CITY OF MERCER ISLAND

July 7, 2017

RE: ADU17-003, CAO17-005, DEV17-009, SHL17-007, SUB17-004 First Review Letter
Land Use Applications for proposed home, ADU, driveway and retaining wall construction within
a steep slope along the shoreline for the Lady Bug Trust

OGDEN POINT RESIDENCE

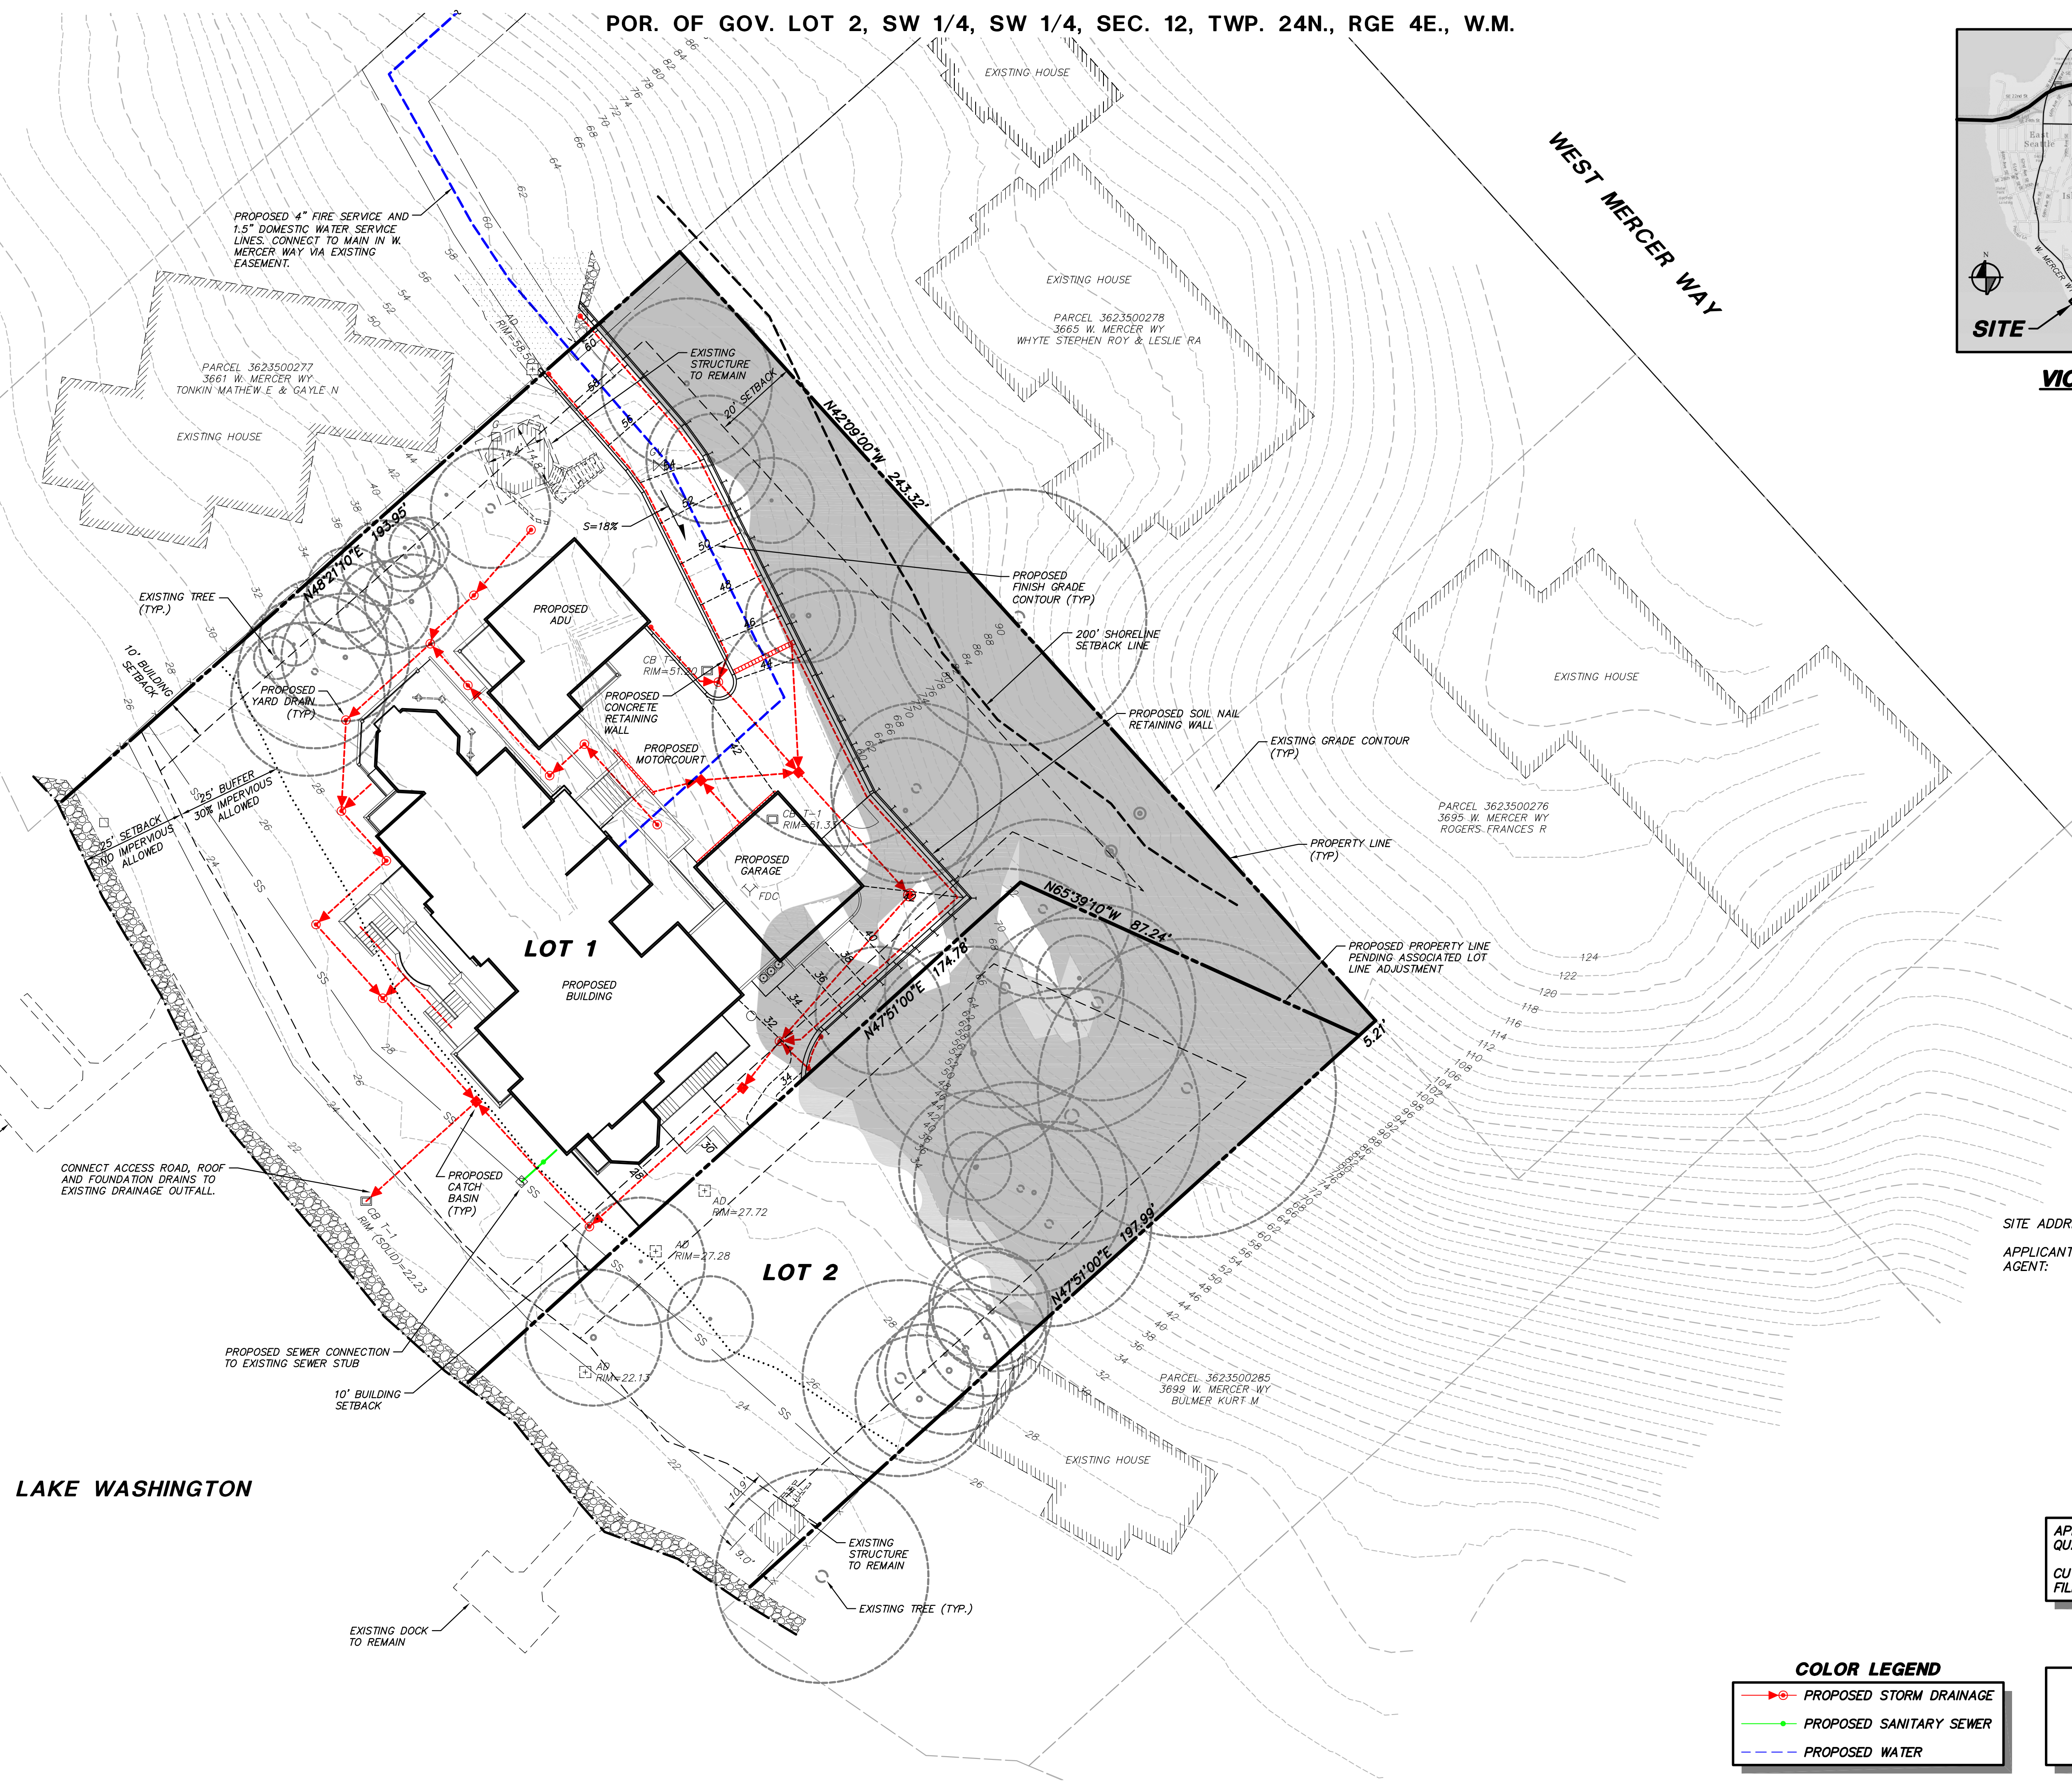
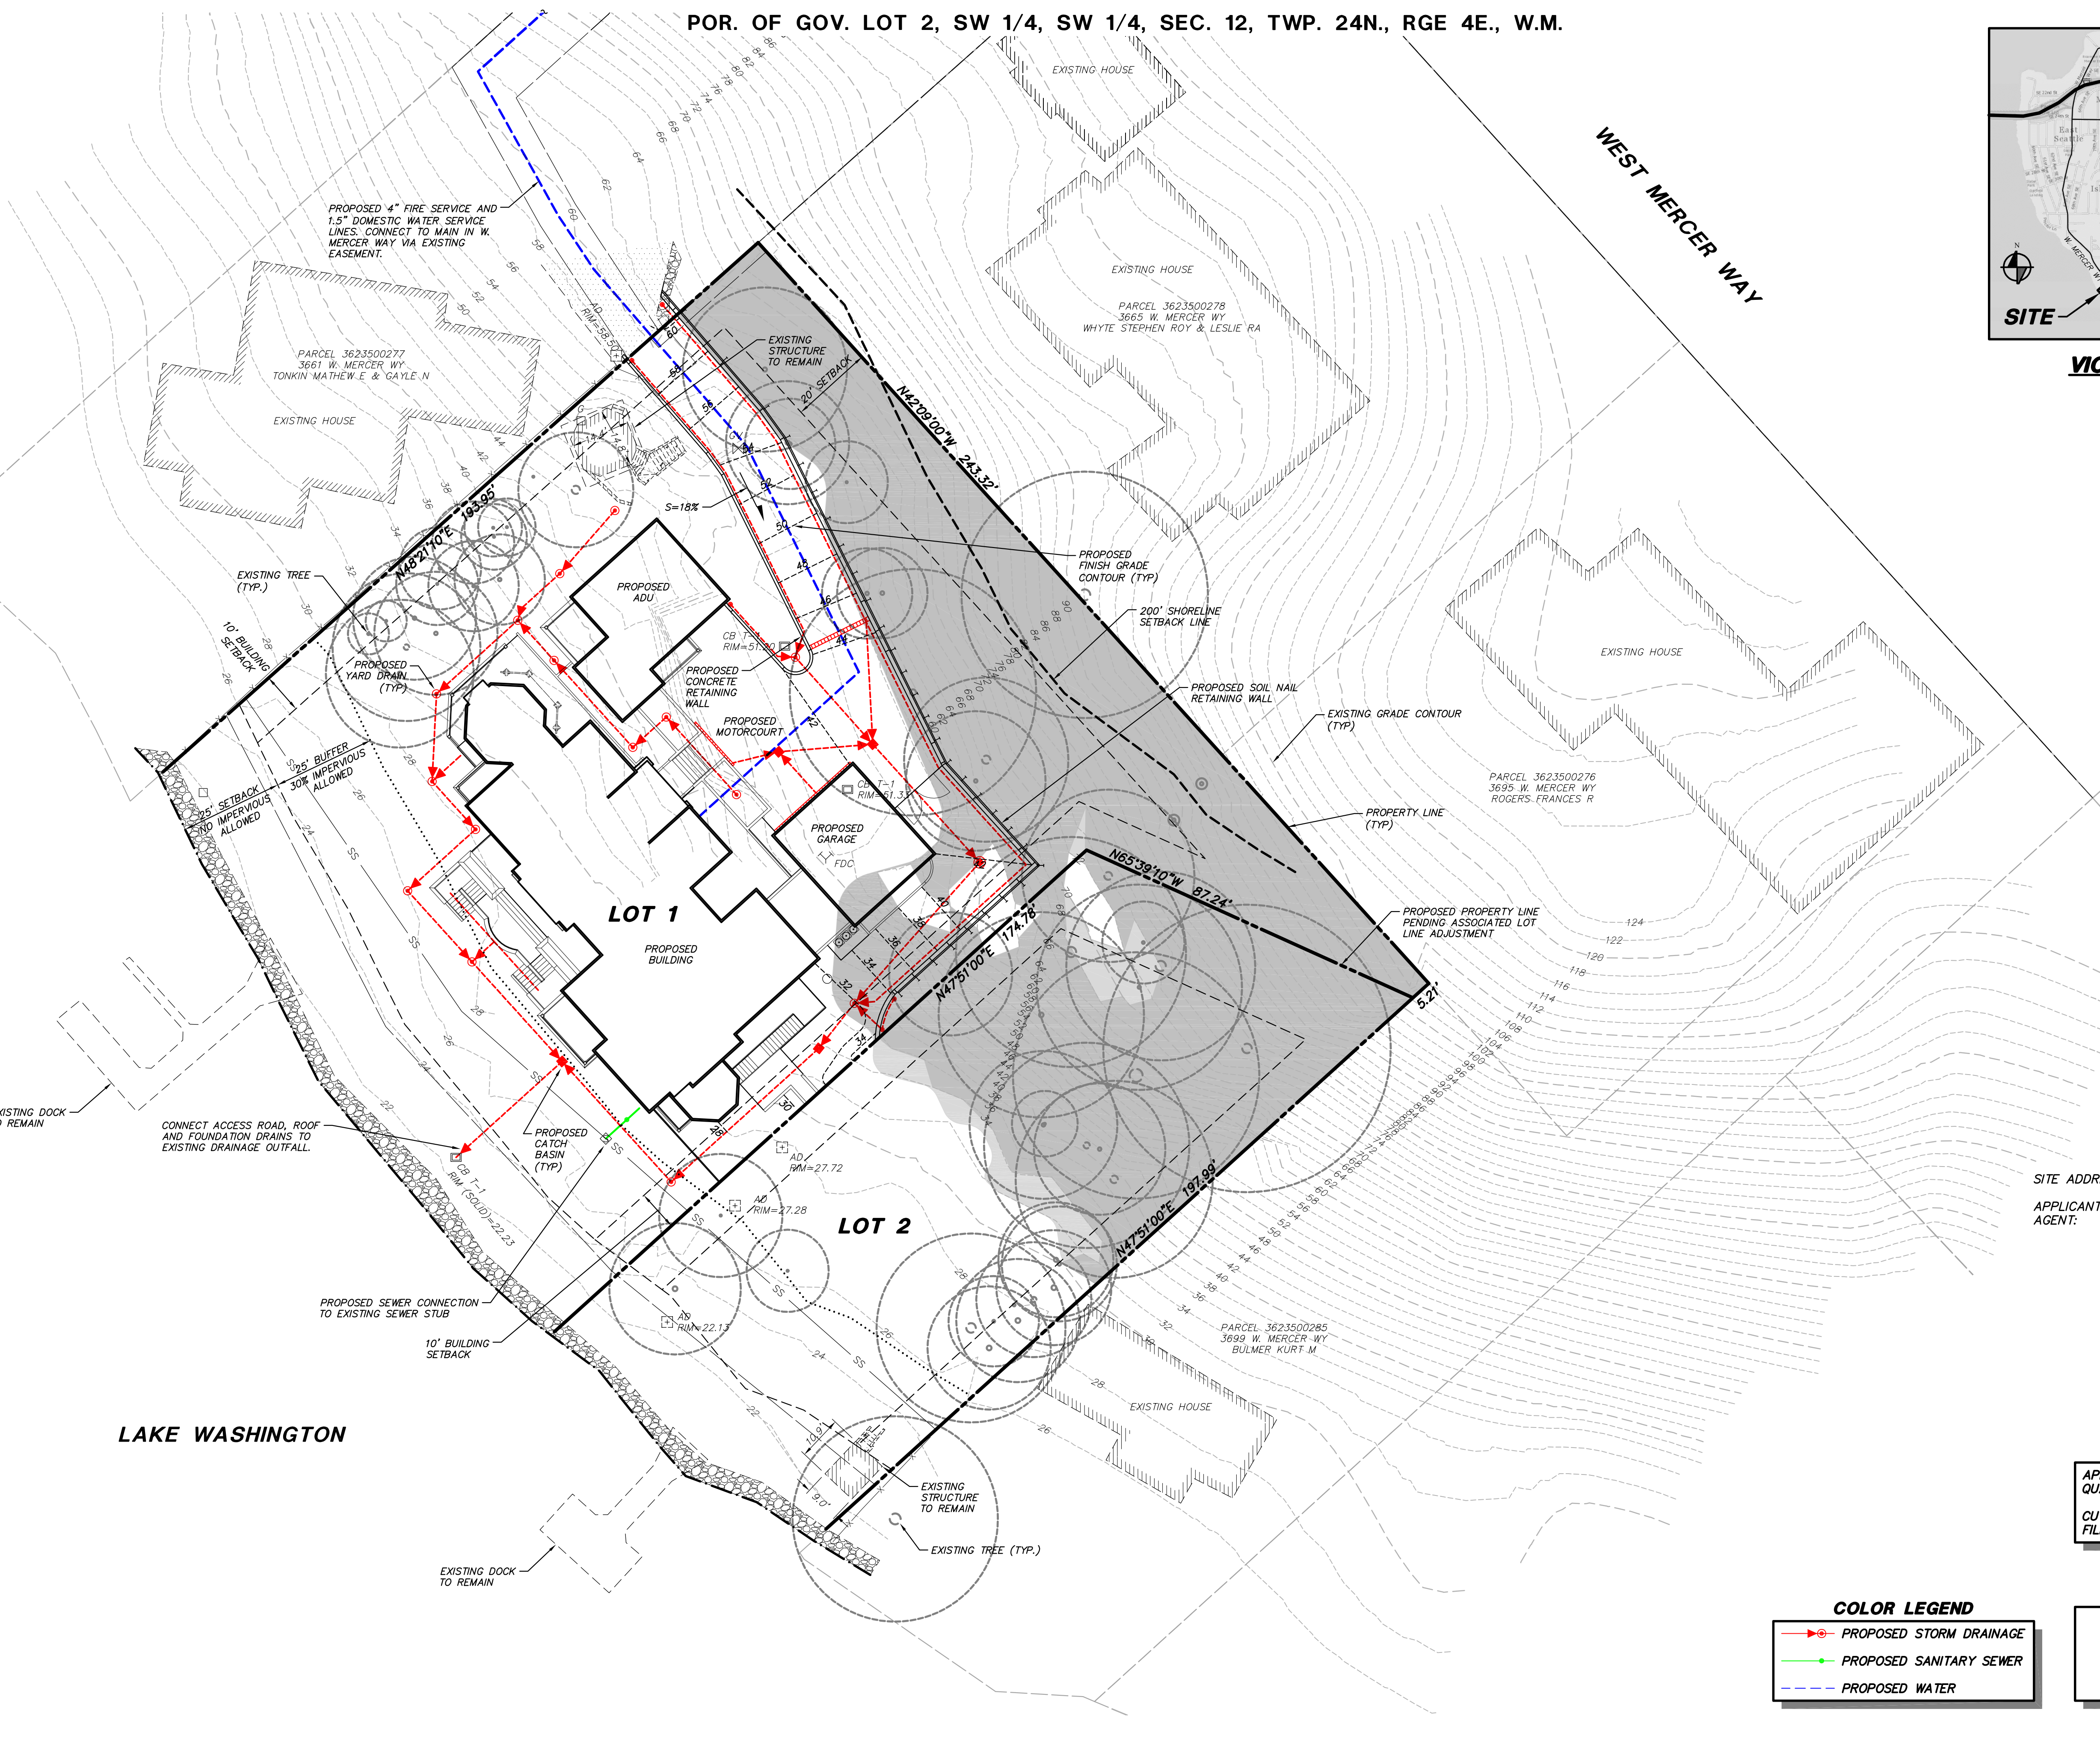
4. Please address the Public Comments (attached). The majority of the neighbors expressed concern over construction impacts along West Mercer Way and the shared driveway.
 - a. The general concern of the neighbors is the possible future construction impacts this project may have. The City anticipates conditioning the land use approval to require that a Construction Management Plan will be submitted for review and approval prior to the issuance of the above land use applications.
5. No structures are allowed within easements, including retaining walls. Refer to MICC [19.02.020\(F\)](#). Please relocate the proposed garage outside the proposed 16-foot-wide

ingress/egress and utilities easement and please relocate the retaining walls out of the 10 foot underground electric system easement.

22. Please indicate the existing public sanitary sewer easement on all site plans. All private utilities, such as storm drainage system, irrigation system, dry utilities (power, gas, etc) shall be located outside the existing public sanitary sewer easement.
